Department of Primary Industries

OUT16/17127

White Rock Solar Farm Project (SSD 7487) Comment on the Environmental Impact Statement

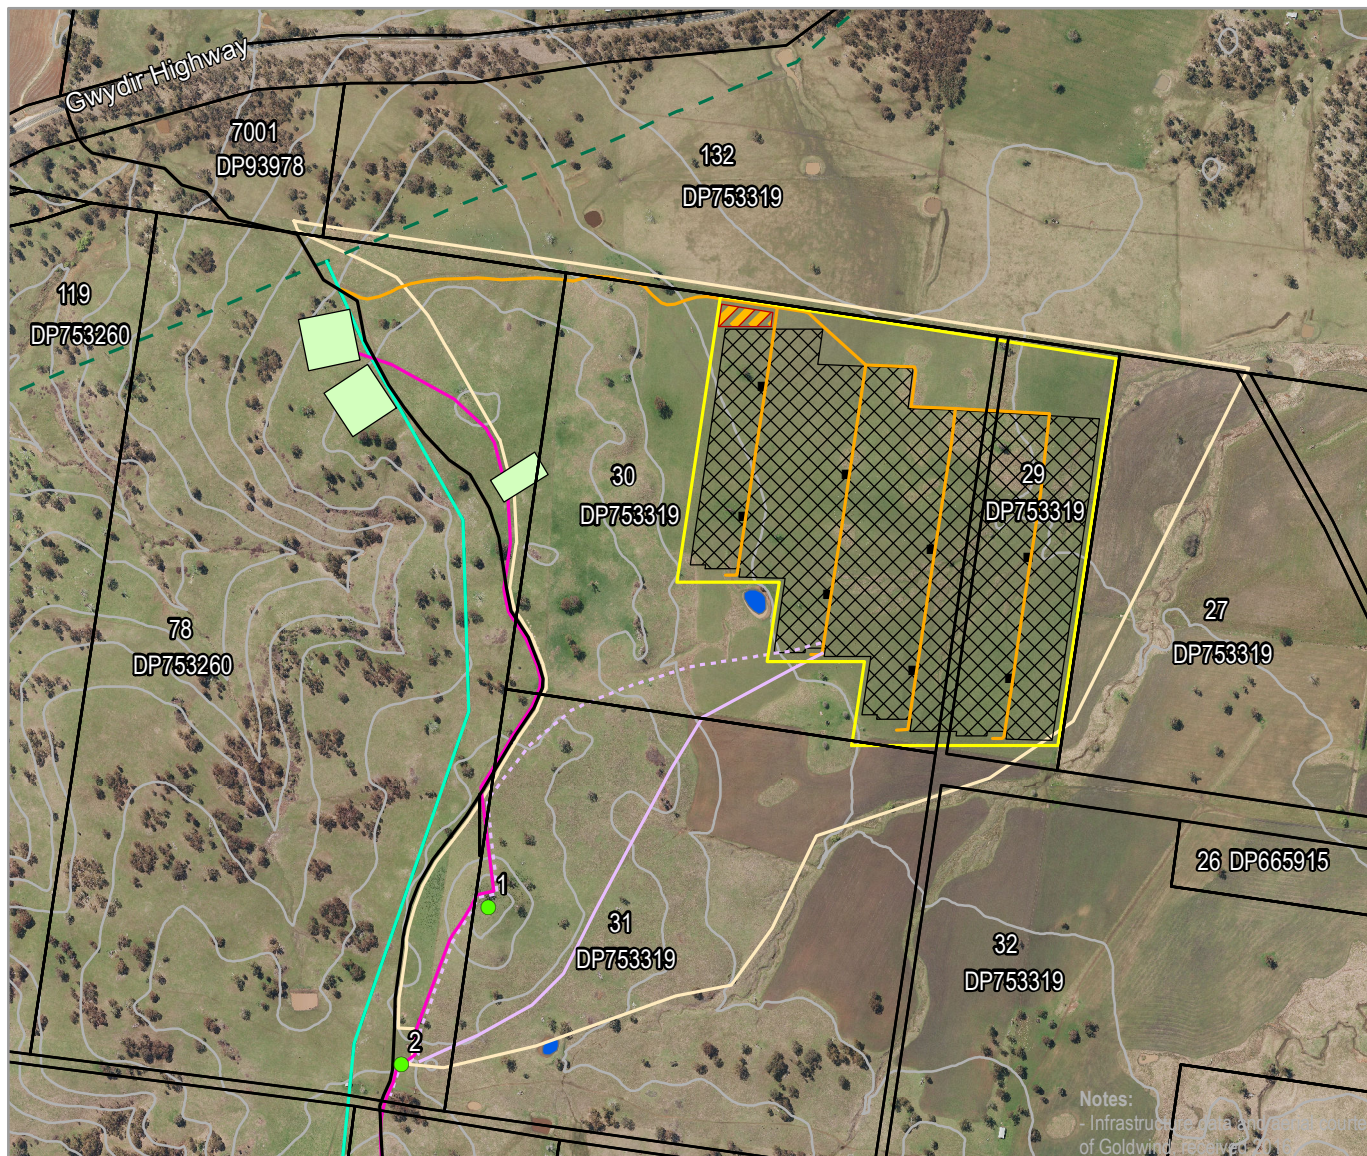
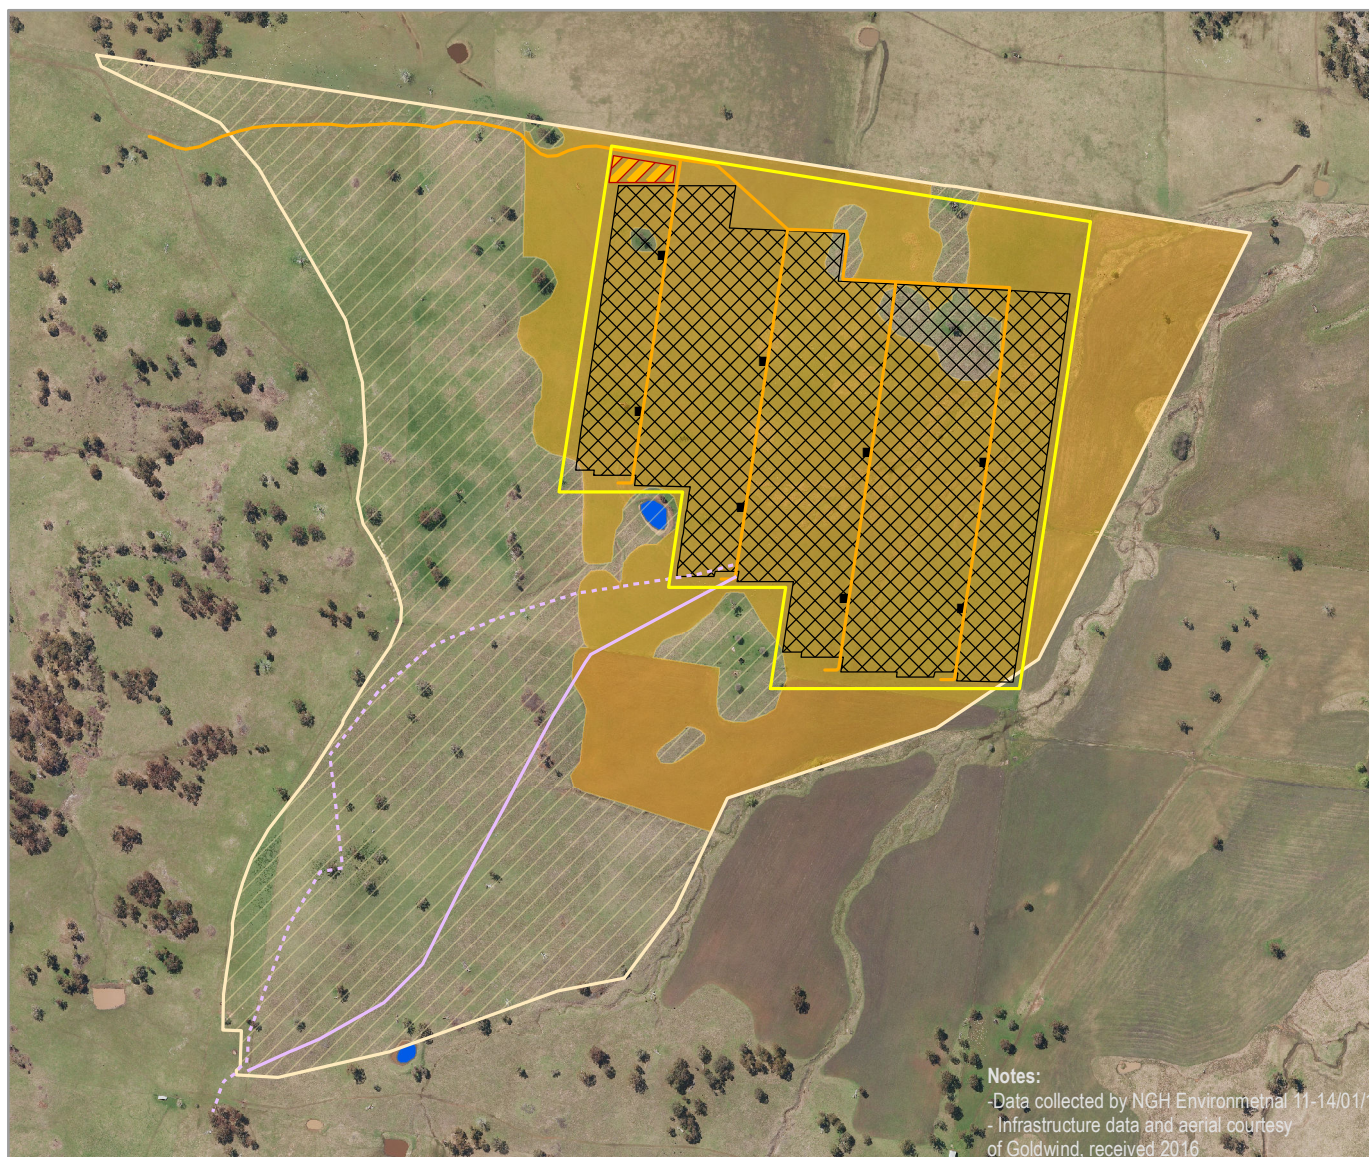
It appears that Figure 9.3 in the EIS shows the solar array located across and within the drainage line on the site. The EIS does not adequately explain how the watercourse will be managed. It is unclear if the proponent proposes to realign the watercourse or fill the watercourse or divert the watercourse around the site. Further information needs to be supplied, including cross sectional and long sectional profiles of the watercourse, by the proponent to enable DPI Water to provide accurate comments on this issue and to determine whether the works proposed are in accordance with the Guidelines.
